## DOCUMENT 4 –

### Response to ExA’s Written Questions

| ExQ1  | Question:   | Canal & River Trust Response   |

Appendix 6

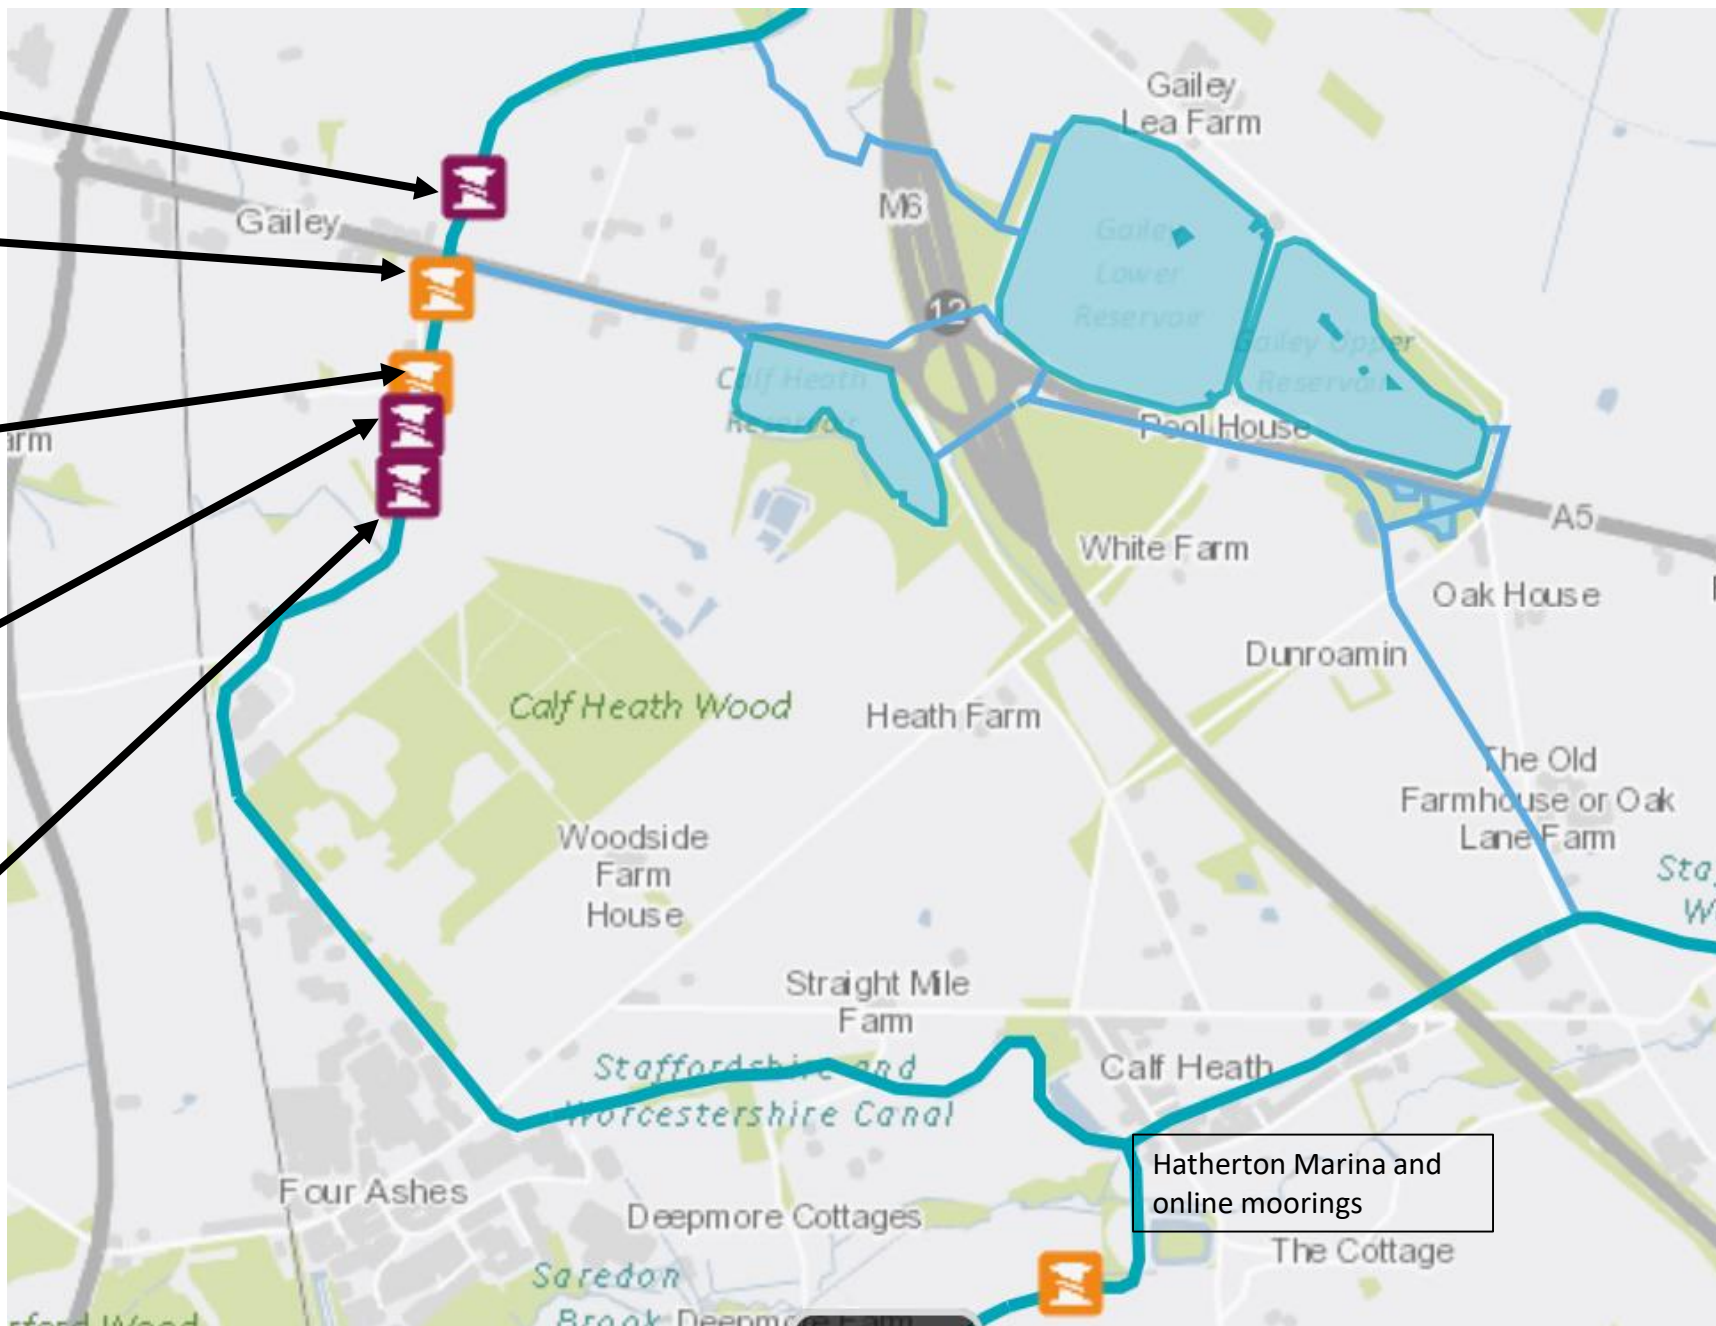
| 1.9   | Noise, Vibration and Lighting   |   |
|-------|---|---|
| 1.9.4 | <p>Paragraph 13.182 states that the northern and southern canal-side moorings are considered to be of medium sensitivity.</p> <p>(i) What is the nature of the use of these moorings and can they reasonably be distinguished from other residential properties close to the application site?</p> <p>(ii) Given the Applicant's acknowledgement as to the practical difficulties on including canal boats in the Bespoke Insulation Scheme (paragraphs 13.295-13.298) do the predicted rating levels at these moorings of at least 10dB above background levels represent an acceptable level of impact?</p> | <p>There are no permanent residential mooring sites within WMI Order Limits. There are permanent leisure moorings at Gailey Wharf (L1) that can accommodate up to 10no. boats and these are let individually on a 12month basis. There are no restrictions imposed on the length of time people can stay on the boats at these moorings for leisure purposes.</p> <p>There are permanent moorings at Gailey Marina associated with the business use. There are other moorings points at Gailey where time restrictions apply.</p> <p>to the north of the A5:</p> <ul style="list-style-type: none"> <li>• Gailey Wharf moorings – 4no. moorings restricted to maximum 48hours</li> </ul> <p>To the south of the A5:</p> <ul style="list-style-type: none"> <li>• Gailey Wharf Service Moorings – 2no.short-stay moorings for services and shop</li> <li>• Gailey Bridge moorings – 2no. moorings restricted to maximum 5days and 4no. moorings restricted to maximum 48 hours.</li> </ul> <p>Outside of these designated moorings sites boats can moor anywhere on the canal network for a period of up to 14days.</p> <p>The location of the moorings can be viewed in Appendix 6 of the Trust's Written Representations, dated 5<sup>th</sup> April 2019.</p> |
